PLANNING DEPARTMENT – Development Review Services

**RE: Hurt Residence, Lot 11, Block 5 Unser Cliffs  
Grading and Drainage Plan  
Engineer's Stamp Date 10-1-14 (File: E10D025)**

**RE: Drainage Resubmittal  
Hurt Residence Lot 11, block 5 Unser Cliffs  
E10-D025**

|  | <p>GRADING AND DRAINAGE PLAN</p> | <p>DATE 07-06-2014</p> |

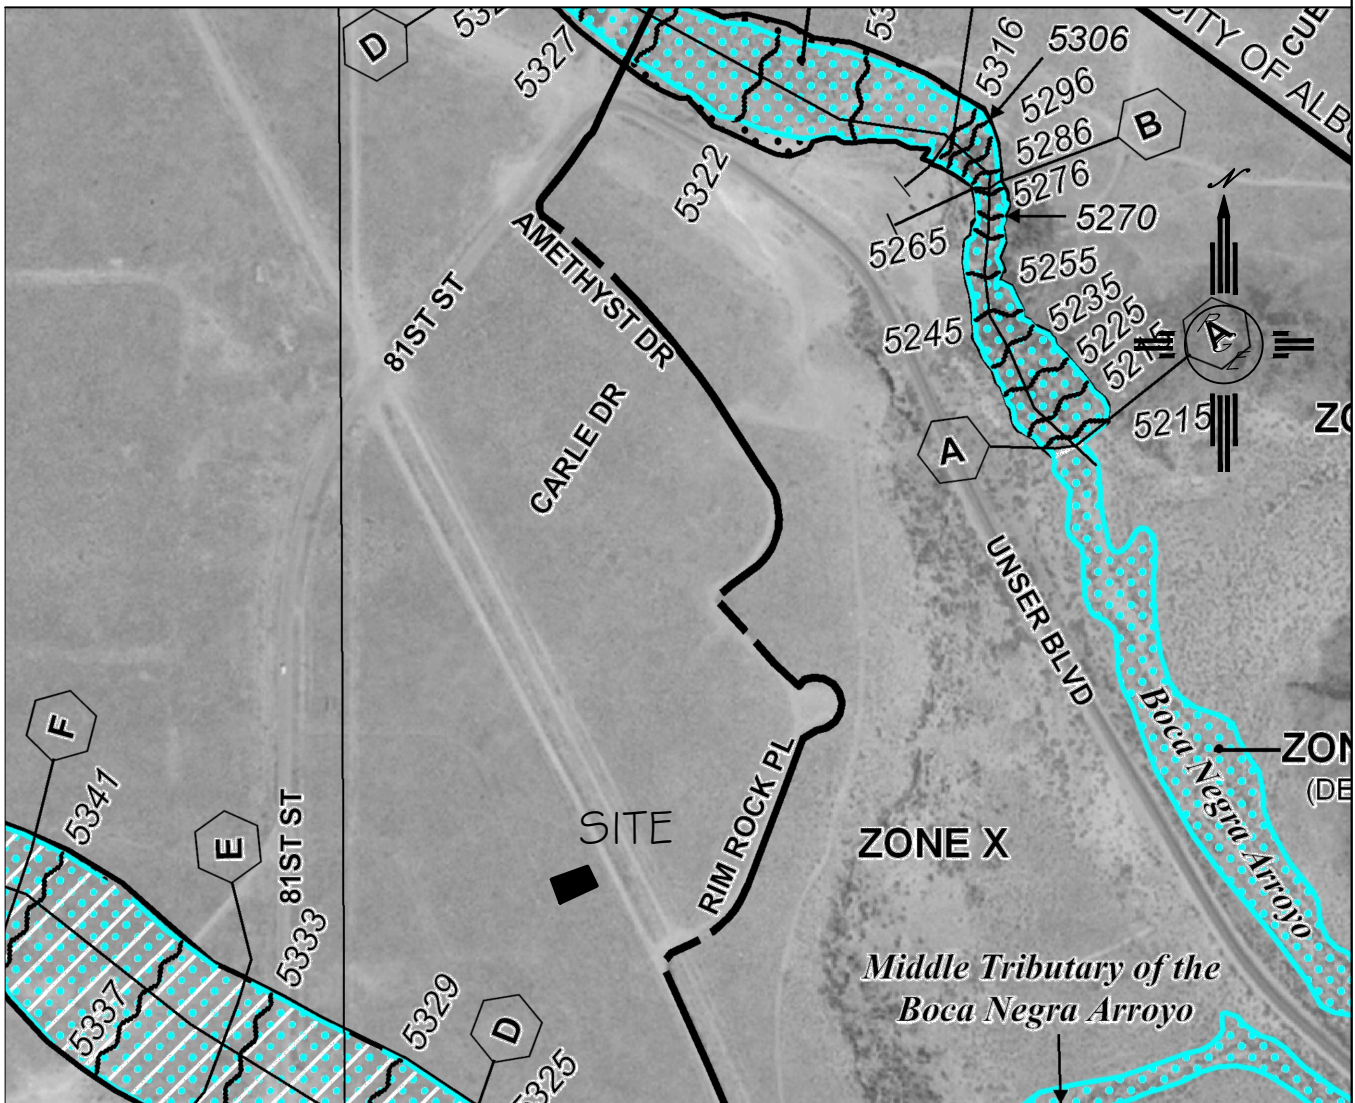
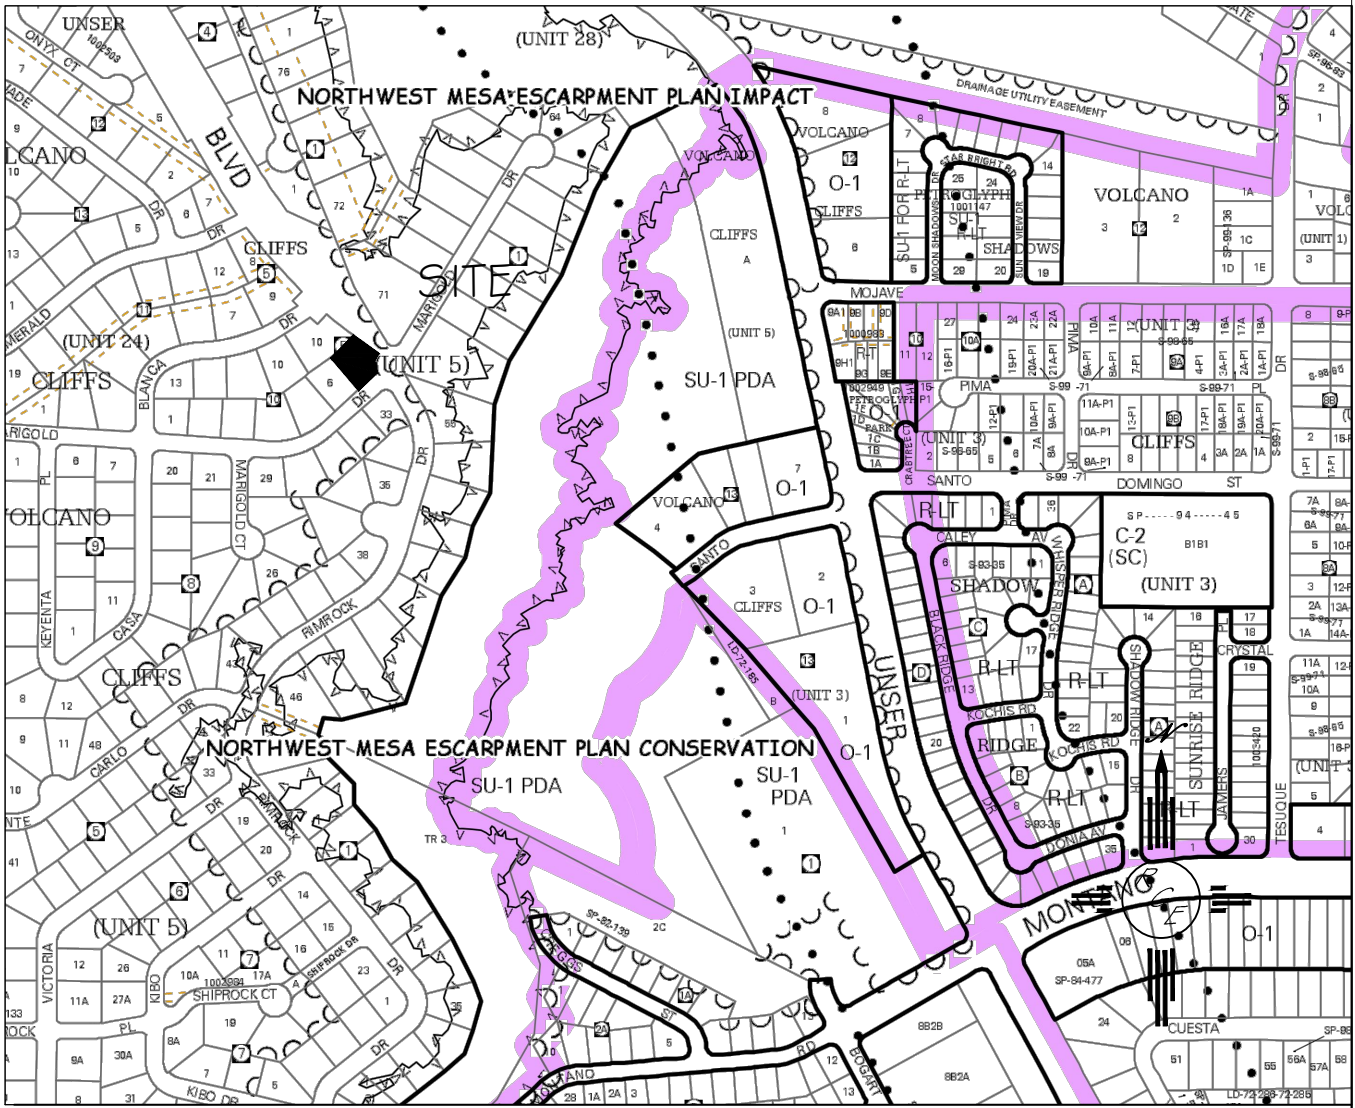
1. Existing contours too light  
**We have darkened**
2. Indicate zone page  
**We have added**
3. provide existing and proposed drainage calcs  
**We have added**

4. Provide drainage narrative  
**We have added**
5. quantify offsite flows  
**We have added on the calculation chart**
6. indicate contributing area  
**We have attached the map, the limits based upon city 2' contours, but we were not able to print out that for format, so we drew on google earth print out.**

7. Show easements.  
**All easements are shown**
8. Turn blocks only on the northeast side. Prove rundown  
**We have added the turned blocks only on northeast side. We have added narrative regarding how offsite flow is handled. The total flow leaving the site is less than existing**

9. Consider draining to marigold  
**Due to roof height restrictions, We are not able to raise the finished floor enough to drain over the top of curb.**
